From: Martyn White <Martyn.White@arun.gov.uk>
Sent: 21 December 2021 17:16
To: Planning.Responses <Planning.Responses@arun.gov.uk>
Subject: LU/397/21/DOC

LU/397/21/DOC

The Farm 39 East Street Littlehampton BN17 6AU

Approval of details reserved by condition imposed under LU/134/21/PL relating to conditions 3- details of the new external doors and windows including sections and their treatments along with details of new porches; 4-details of proposed removal of existing unsympathetic modern windows and their replacement and re-use of existing traditional windows; 5-all new internal joinery such as doors and skirting boards; 6-details of proposed location, heights, materials and finishes of boundary treatments & 9-on site cycle parking storage.

Cellar, Ground Floor and First Floor Plans -
Proposed
Discharge of Conditions

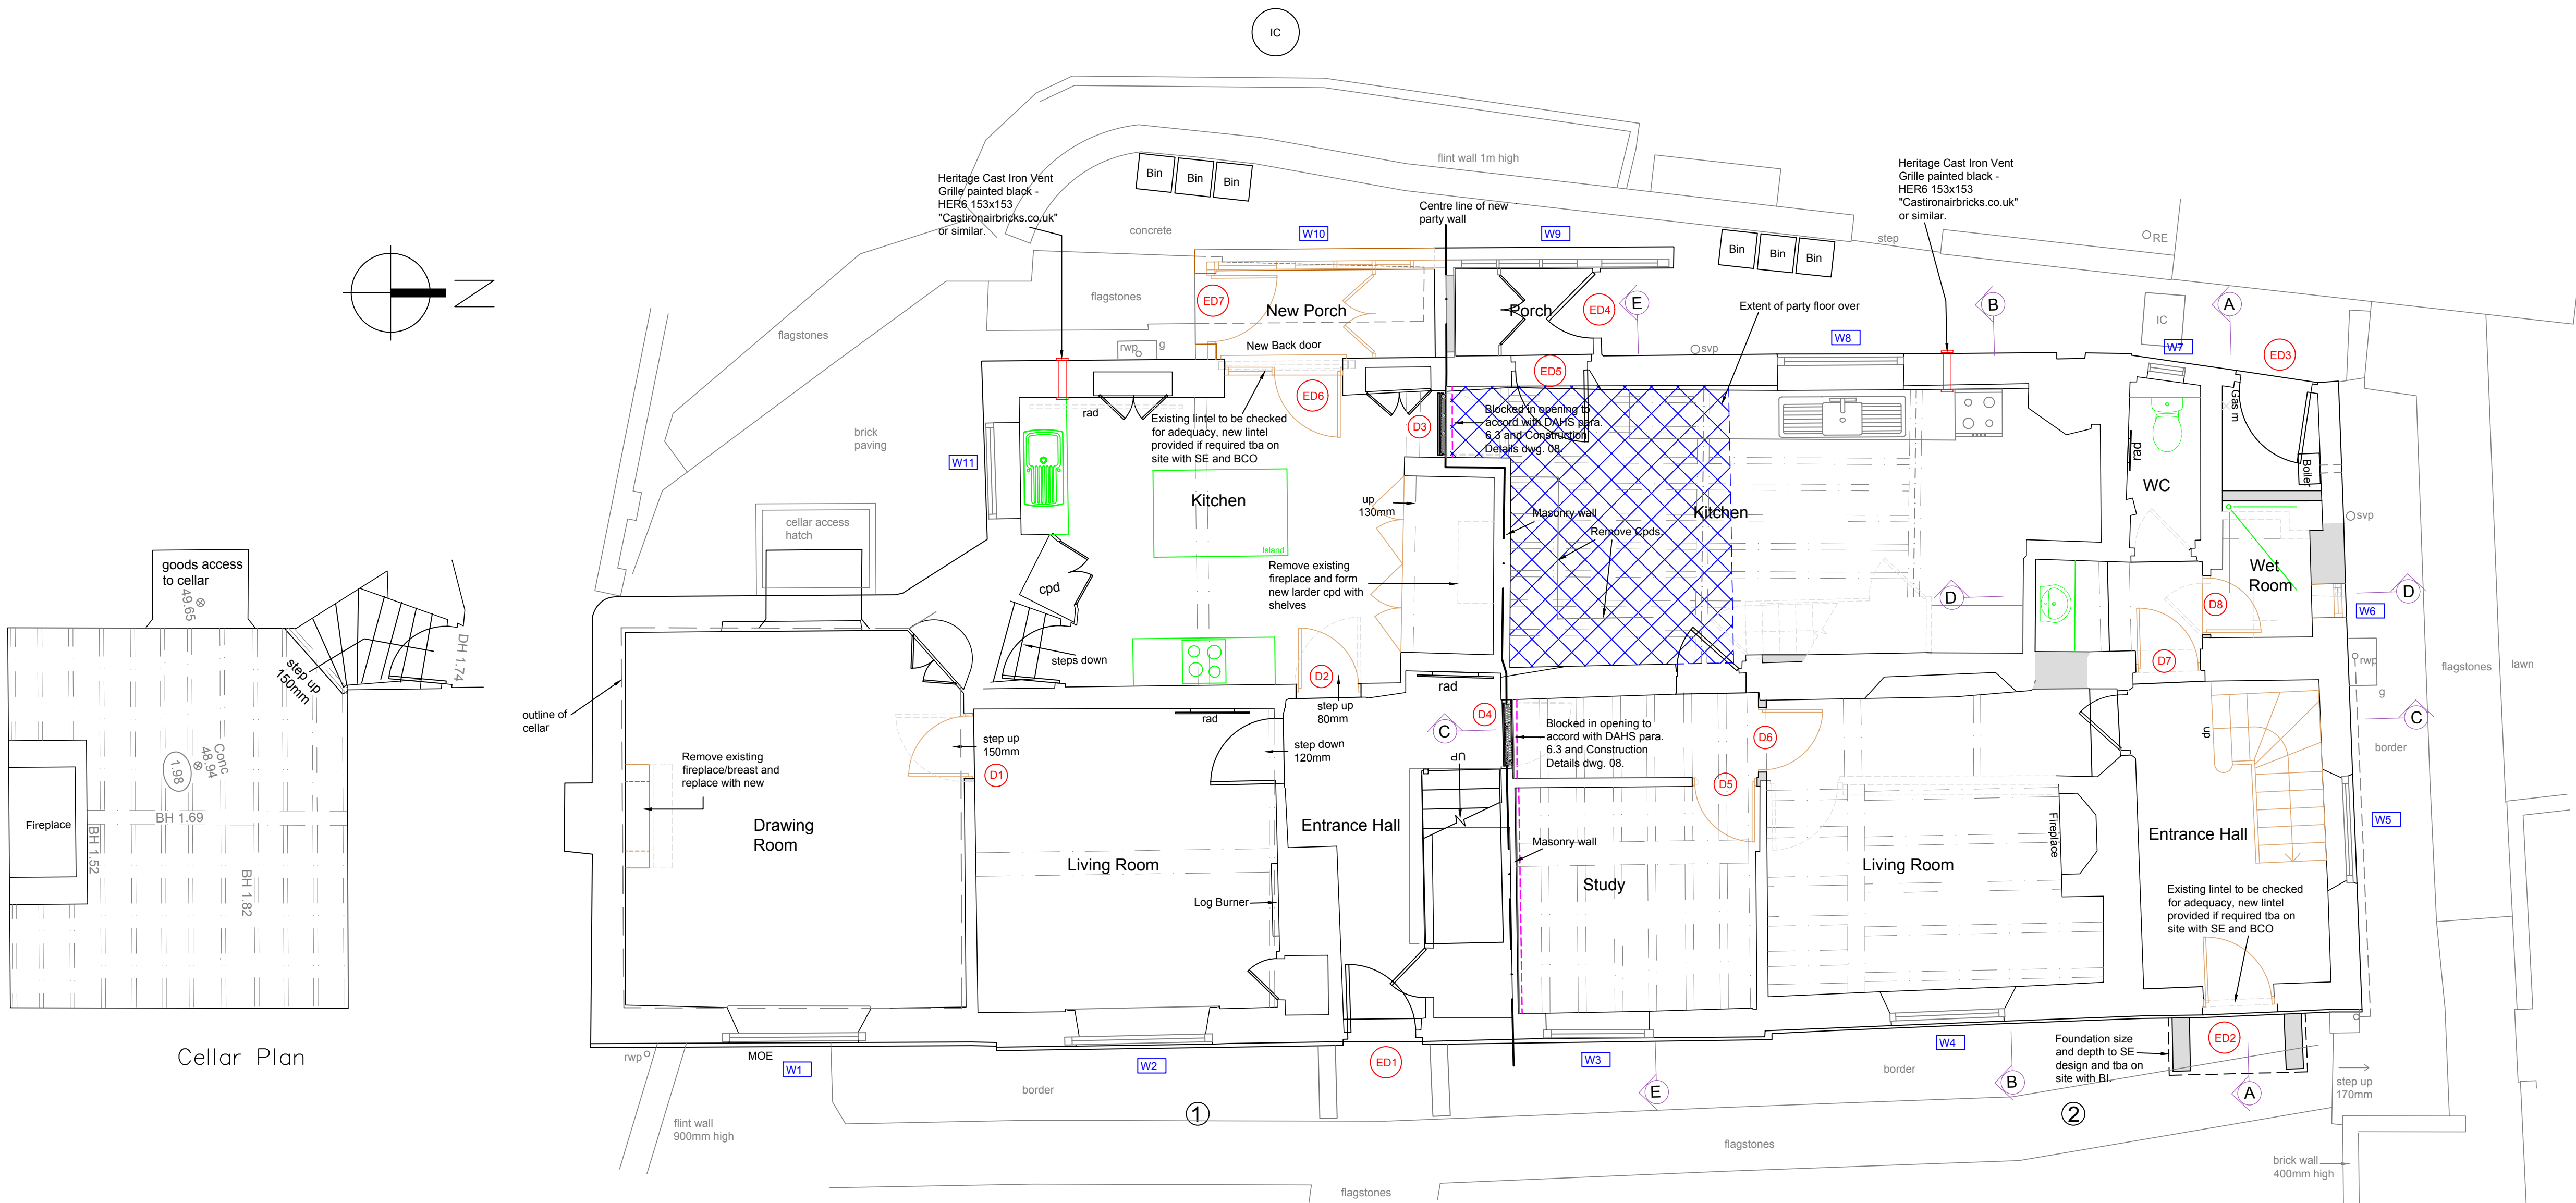
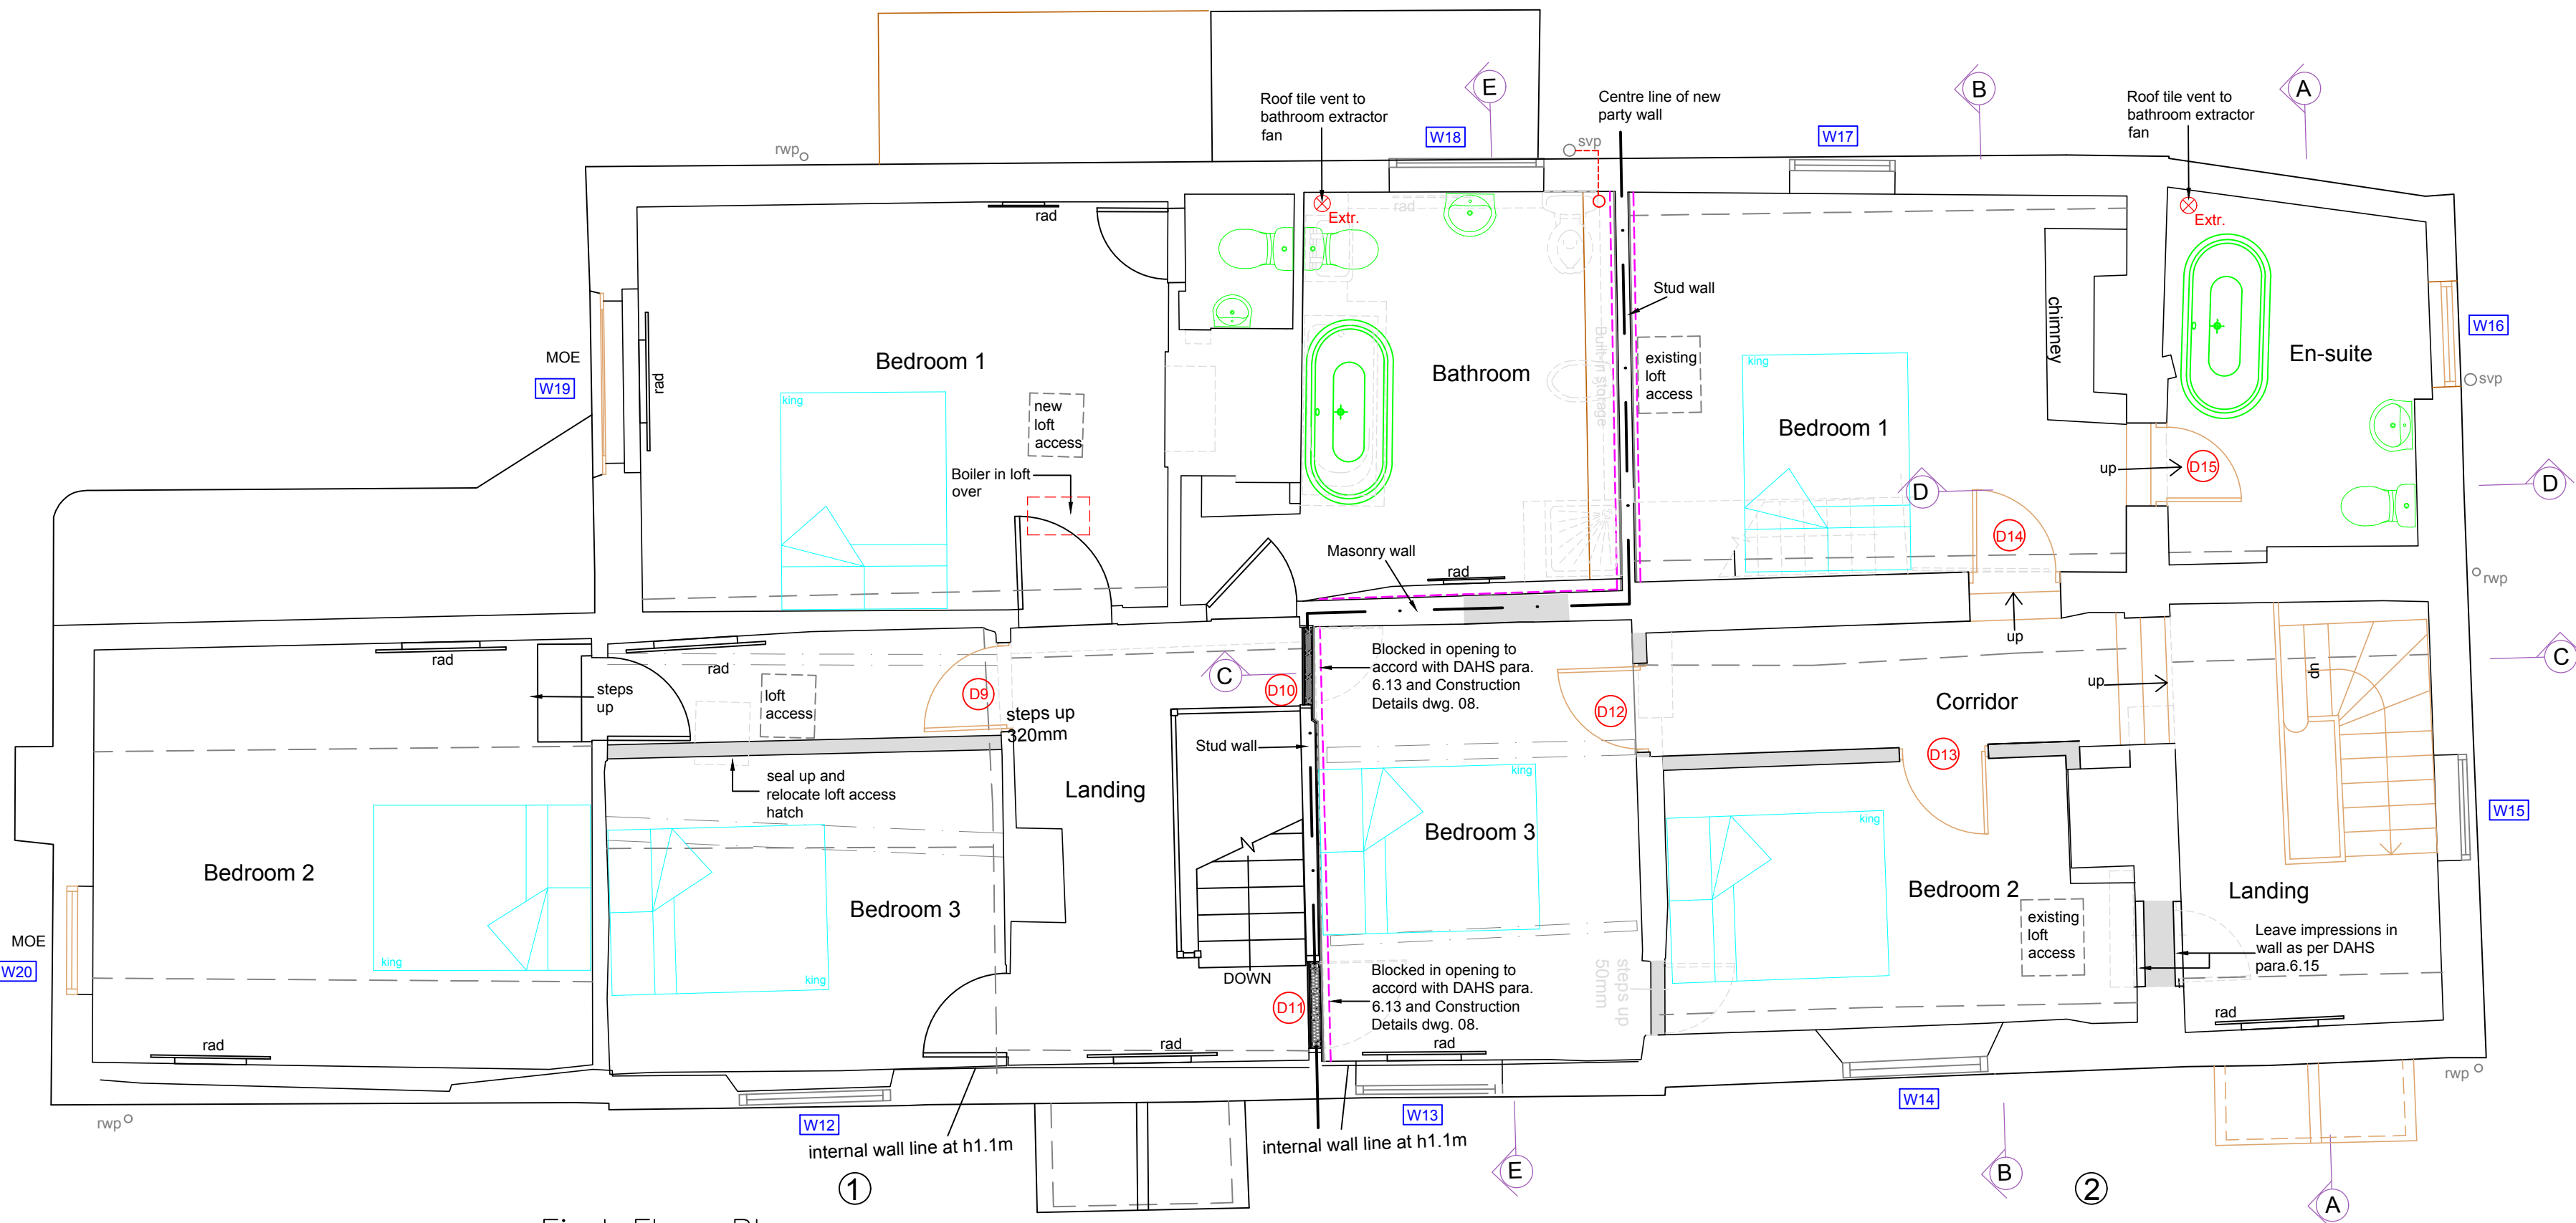
Conditions 3 & 4 – I am unable to locate the section of the windows in unit 2: GF W6 and FF W16. The statement indicates that FF W16 will match the existing FF window on the same elevation. However, this is not fully clear from the drawing of the front elevation only.

Further, I am unable to see an information regarding the window for the porch W10 or the replacement window/door identified as ED6.

Furthermore, it is not clear if any works are planned to take place to W1. This needs to be clarified.

Condition 5 – details of the internal doors and skirting seem to be acceptable.
